FULL

Reference:	H19-0782-16	Date of Decision:	17th October 2016
Applicant:	Mr & Mrs M Ward Ashtree Farm 92 Guanockgate Road Sutton St Edmund Spalding Lincs PE12 0LU		
Location:	Ashtree Farm 92 Guanockgate Road Sutton St Edmund Spalding		
Description:	Proposed barn conversion

South Holland District Council hereby give notice that this application has been REFUSED for the above proposal for the following reason(s):

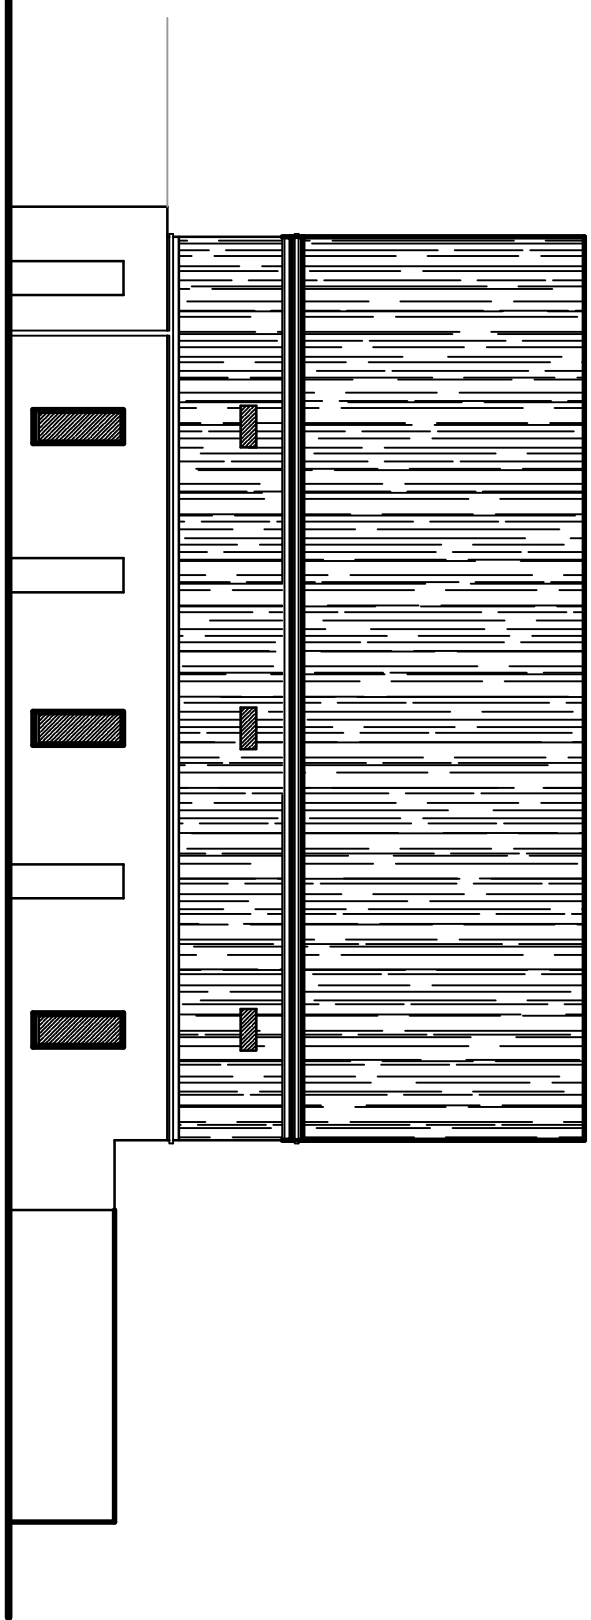
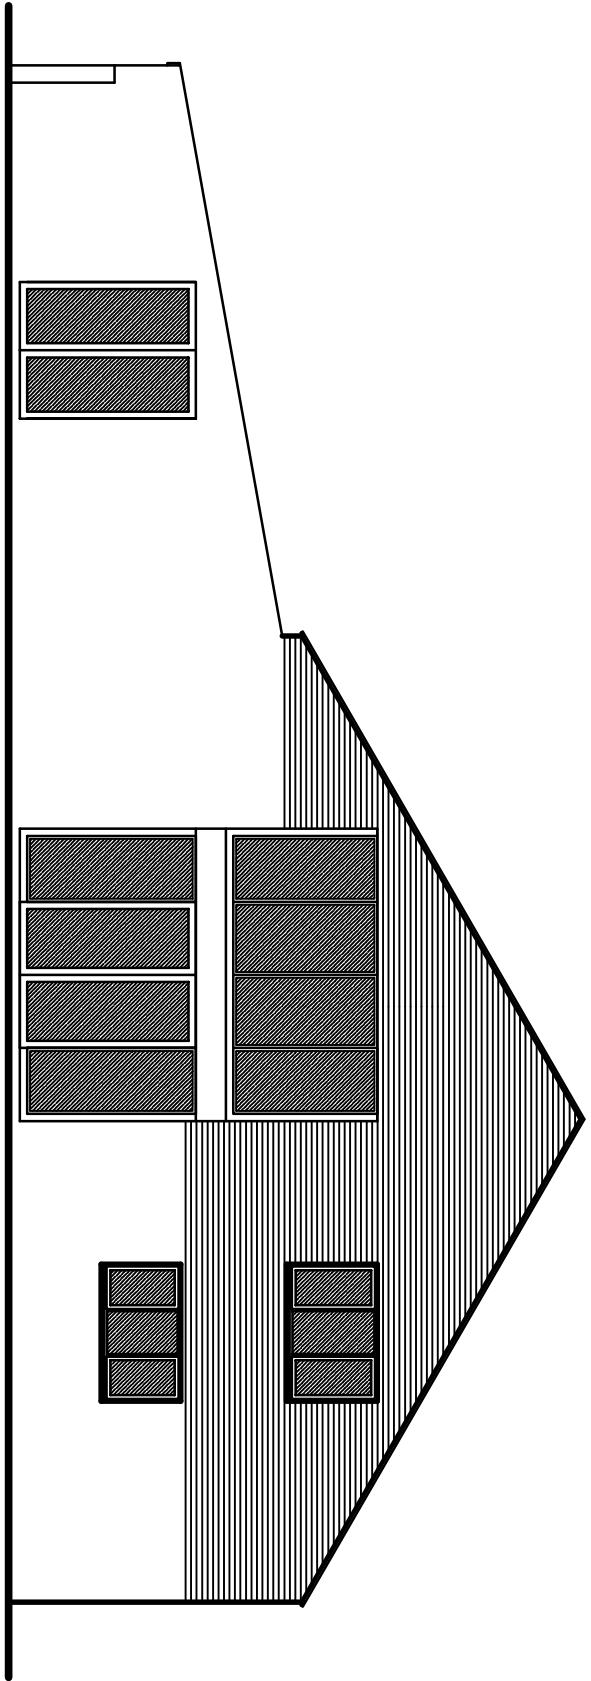
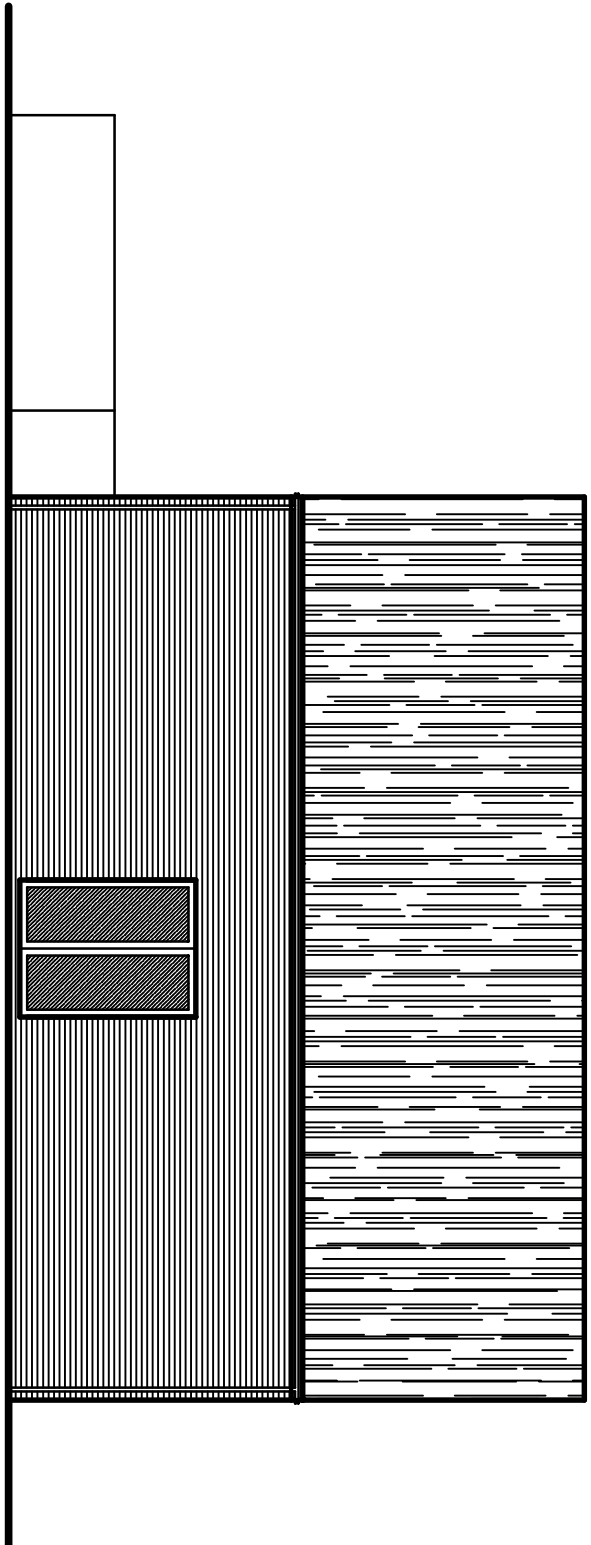
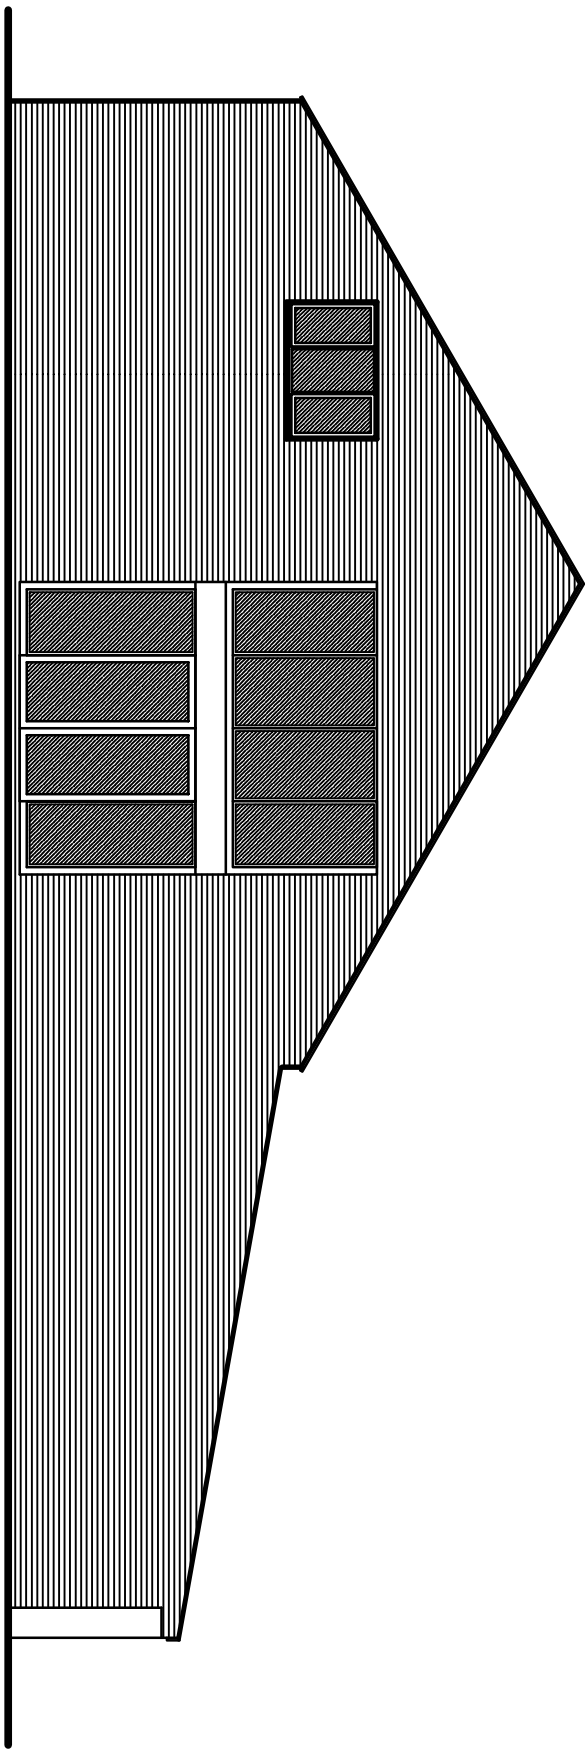
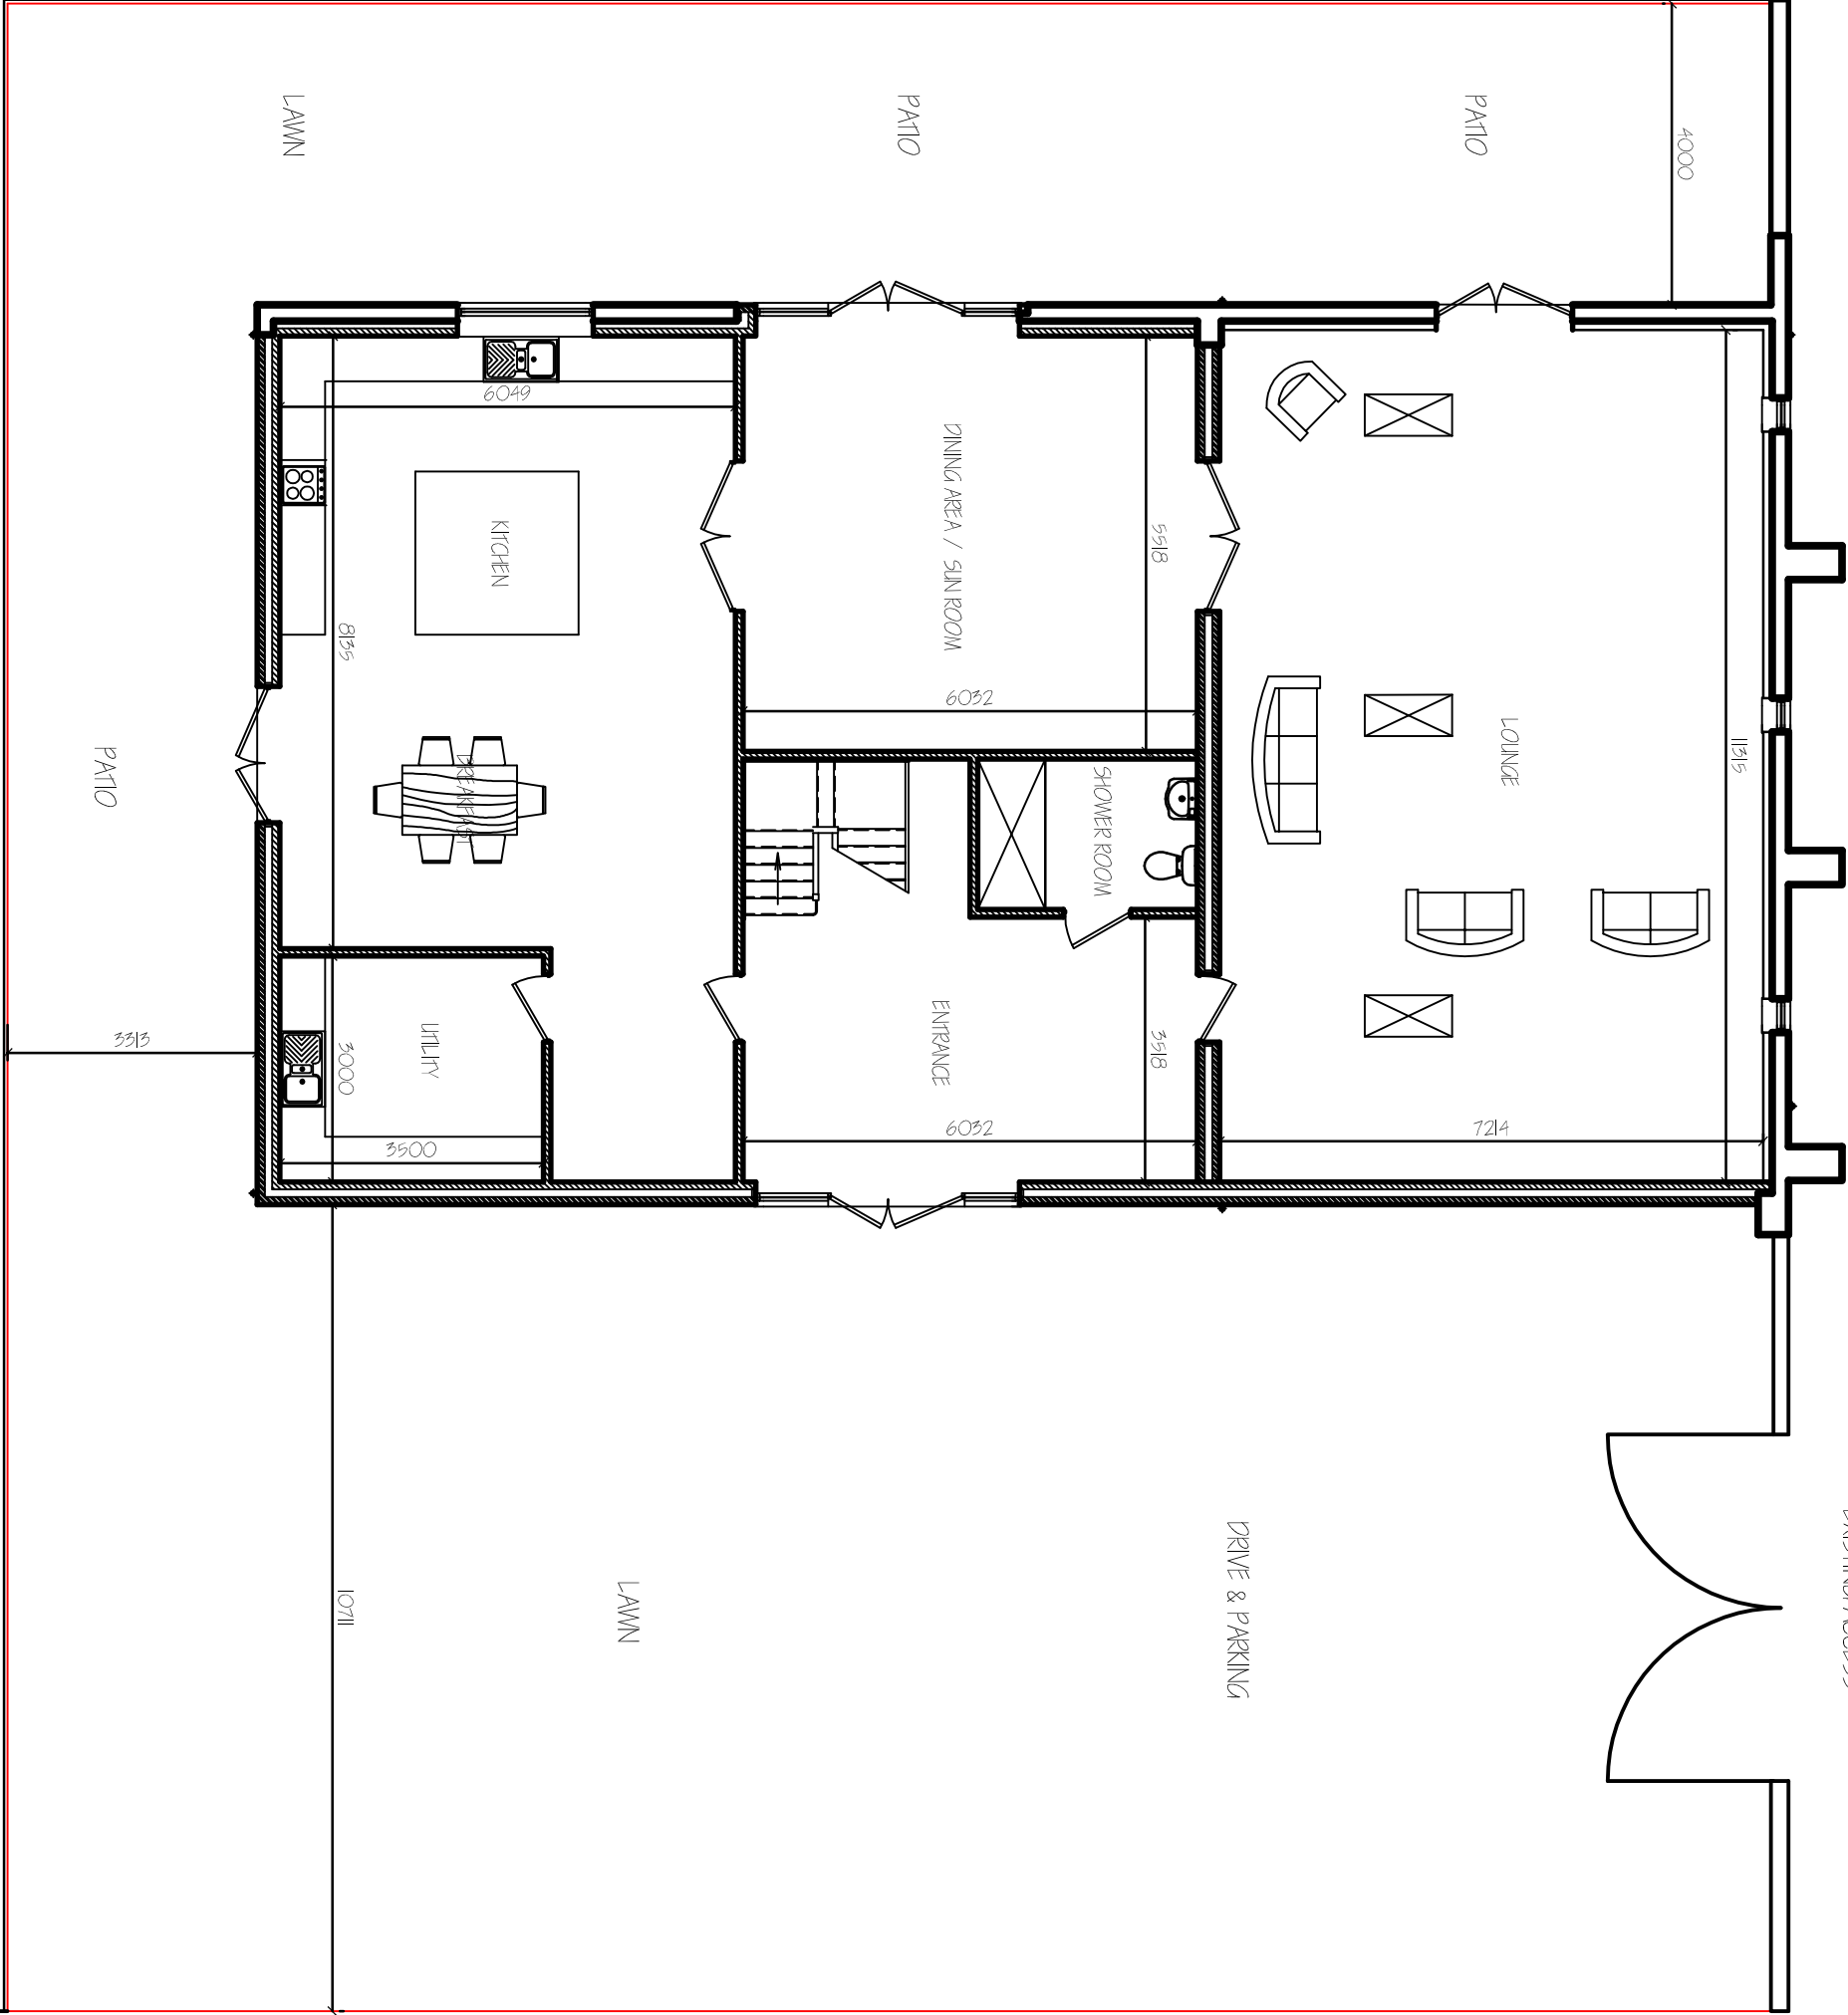
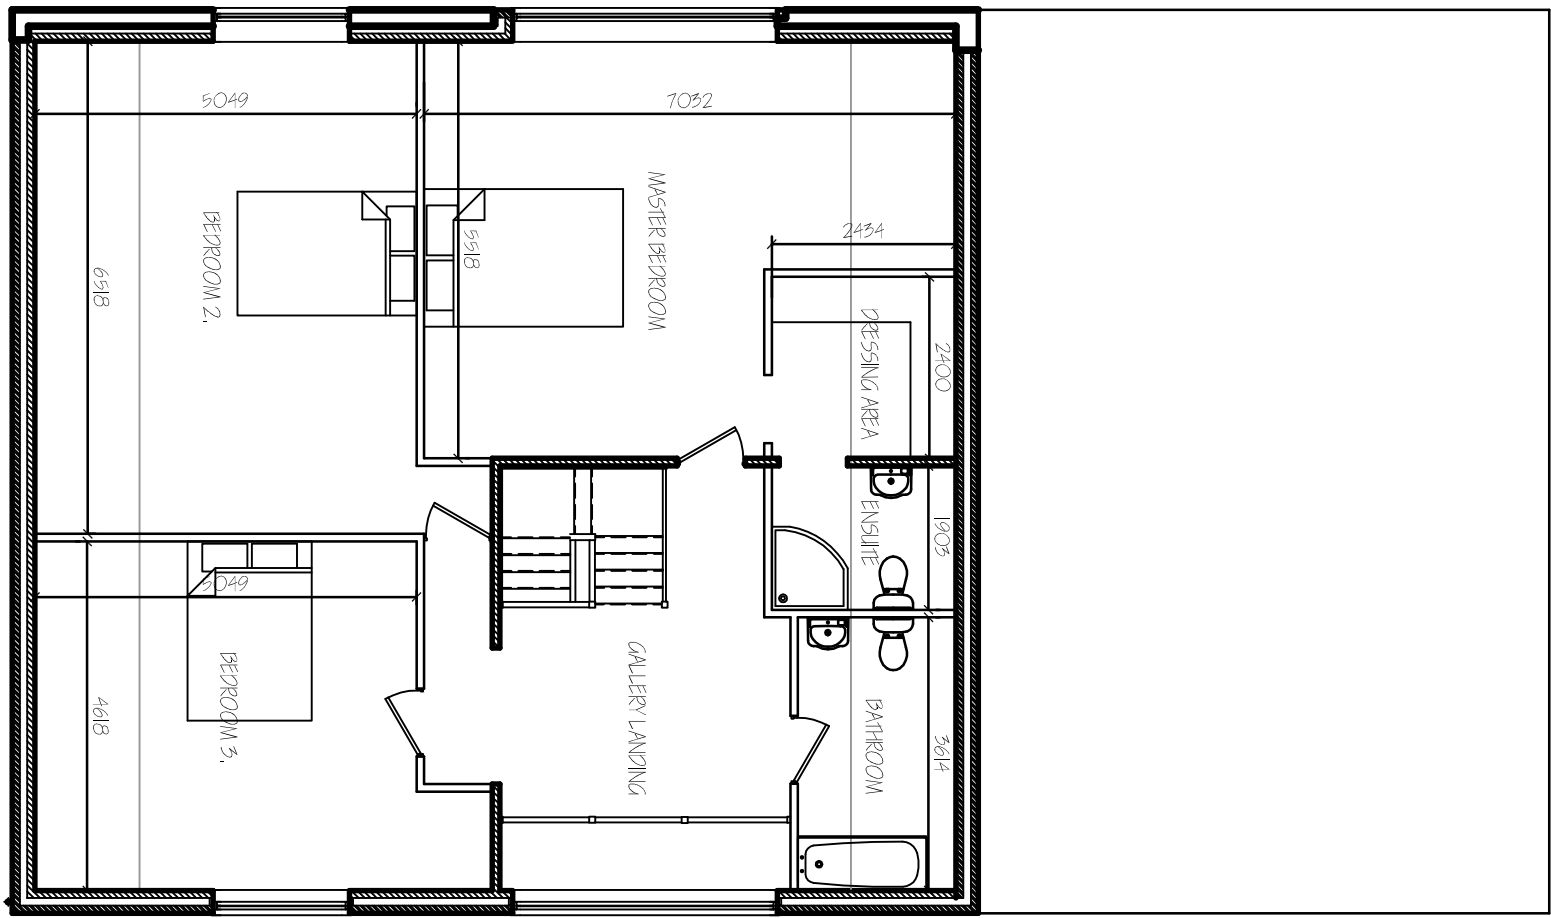
- 1 The building is not of significant architectural or historic merit. Moreover, the proposed scheme would involve significant alterations. The proposal therefore fails to accord with Policy HS16 of the South Holland Local Plan, 2006. The aim of this policy is allow the conversion of rural buildings only under special circumstances where, inter alia, they are a valuable resource and capable of conversion without significant alterations that alter their rural character. It is in accordance with advice within paragraphs 17 and 55 of the National Planning Policy Framework, 2012, which seek to avoid new isolated dwellings in the countryside, except where there are special circumstances, and also to protect the intrinsic character of the countryside.
